Subject: Environmental Impact Statement - 225-245 Martin Road, Bradfield Bulk Earthworks (SSD-97711727) (Liverpool City)

CPHR comments on the Environmental Impact Statement - 225-245 Martin Road, Bradfield Bulk Earthworks (SSD-97711727) (Liverpool City)

FIGURE 14

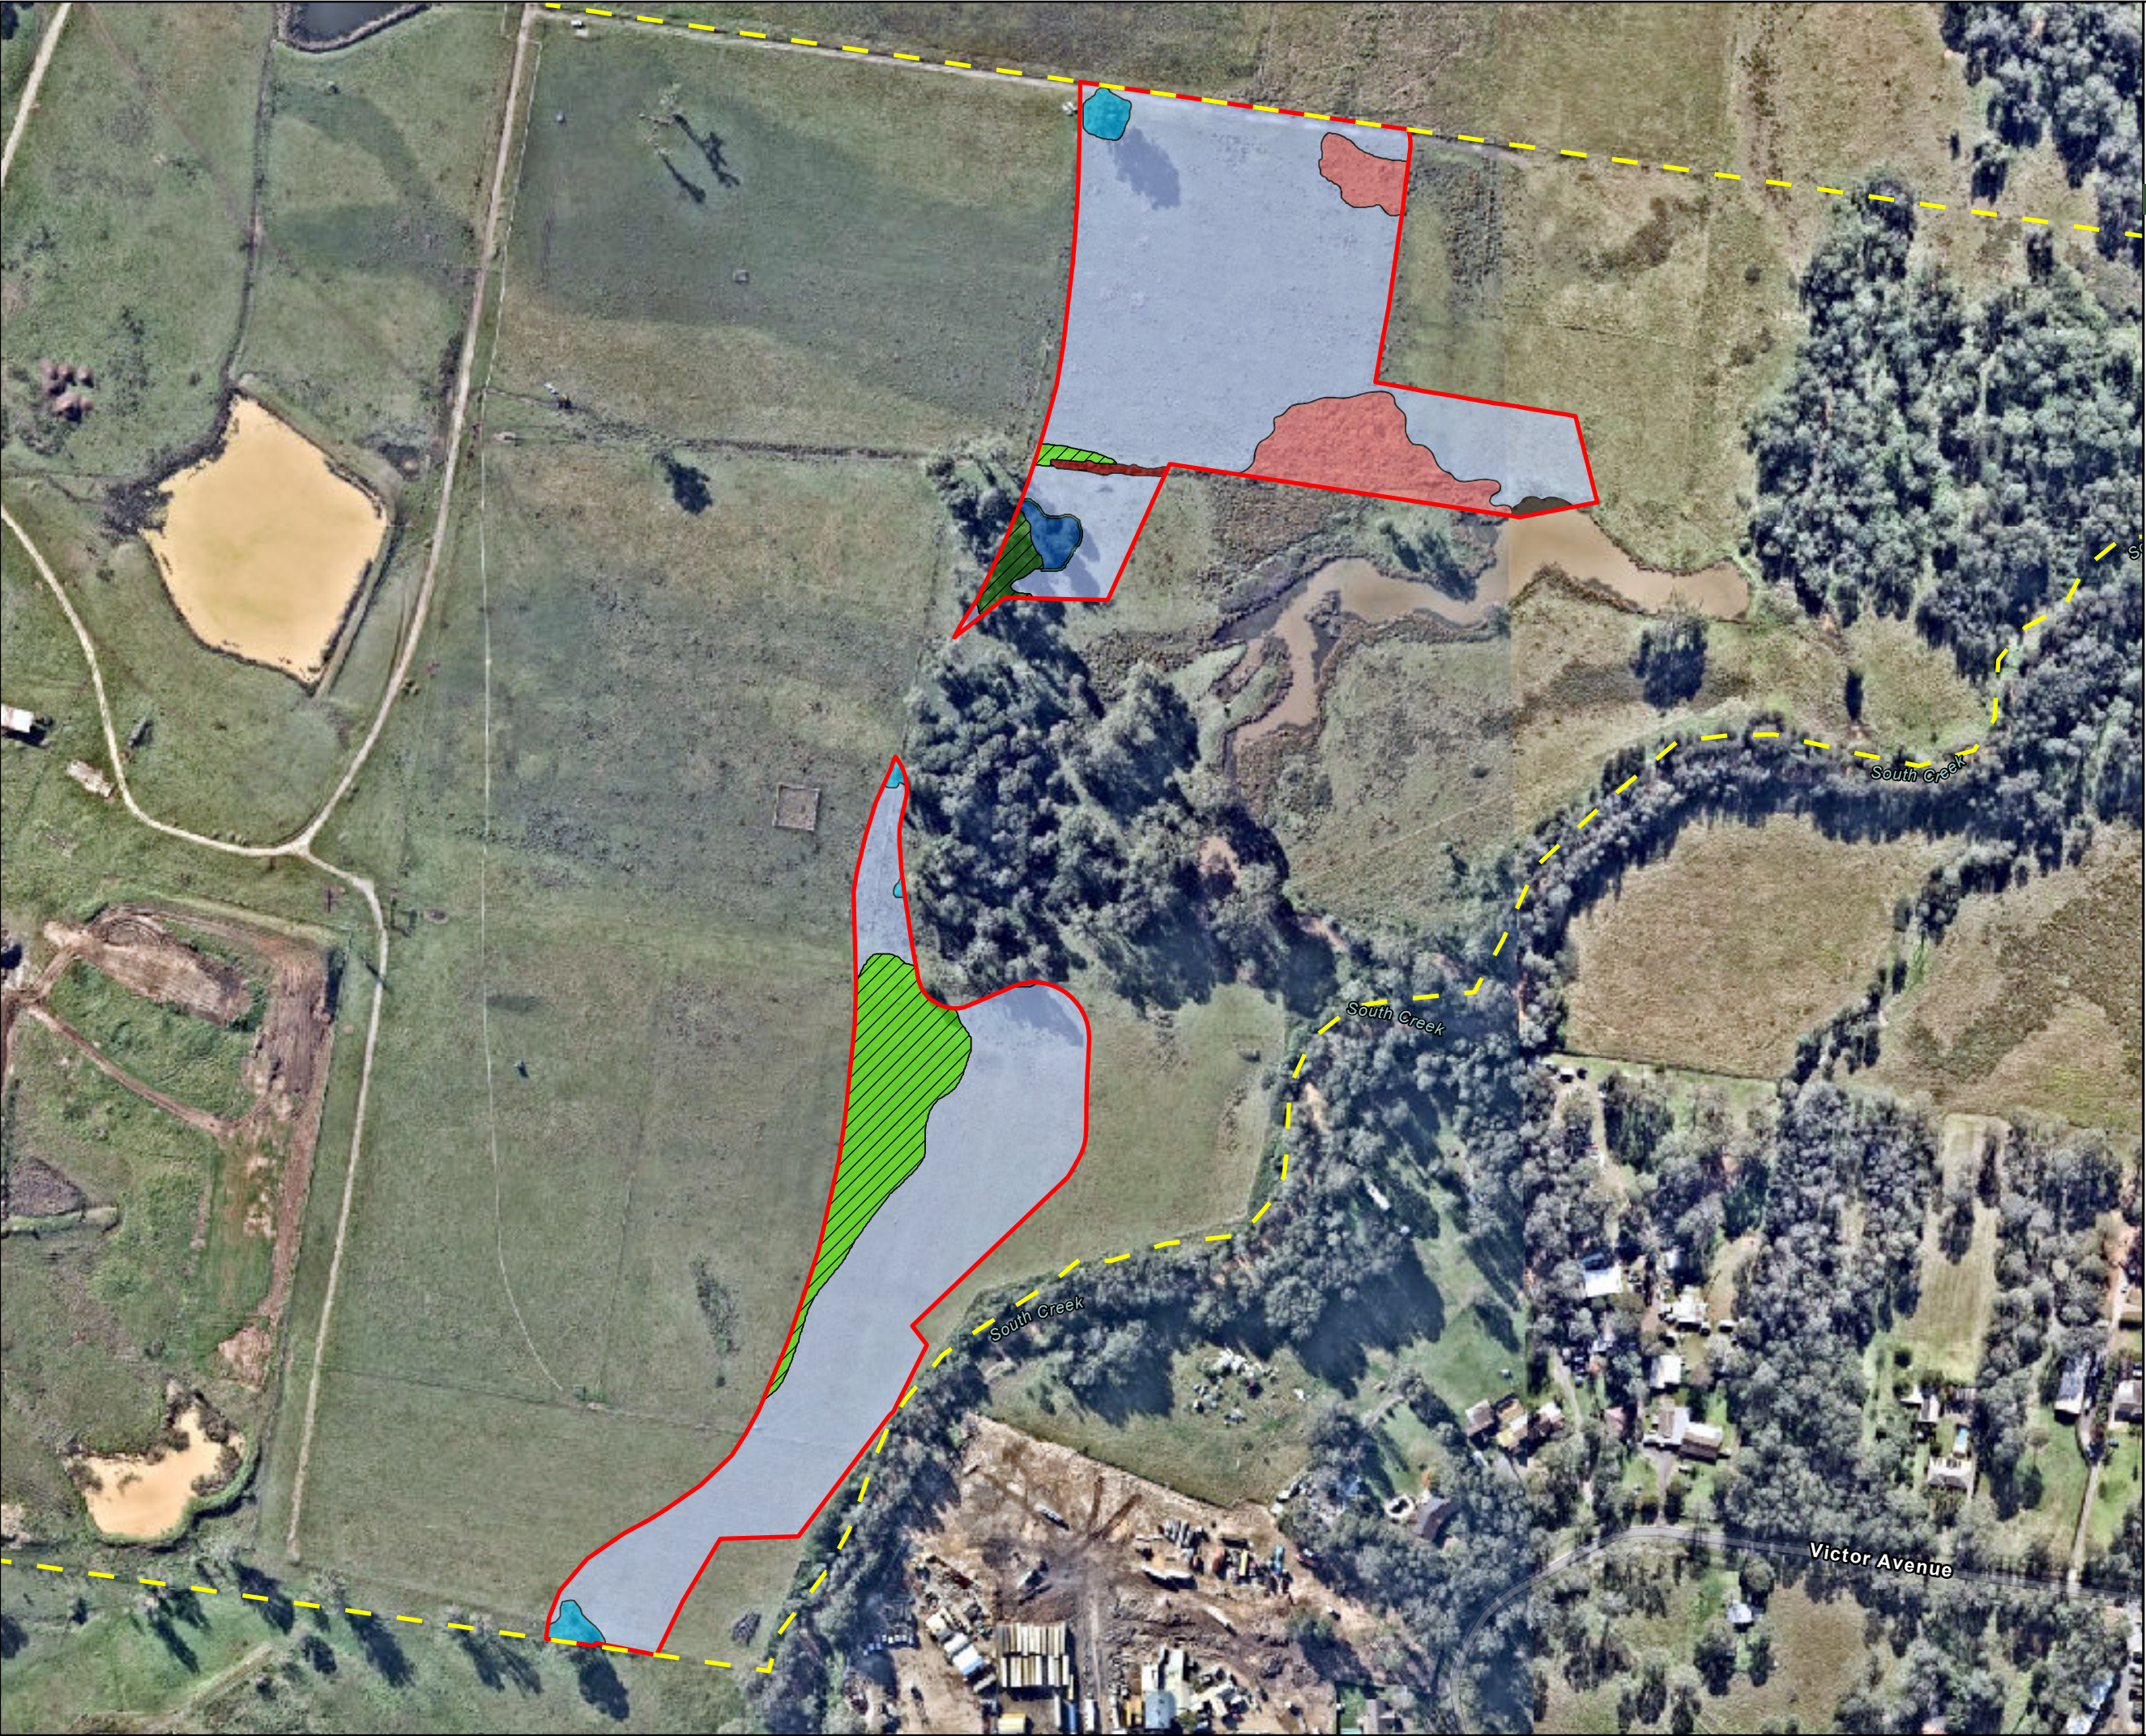
9.	<i>Impact figure missing</i>	BDAR Figure 14 does not clearly show impacts requiring offset, impacts not requiring offset, and areas not requiring assessment Recommended action: Amend BDAR Figure 14 per BAM section 9.2.1 and Table 24 as above.
	<i>Extent and Timing</i>	Prior to determination.
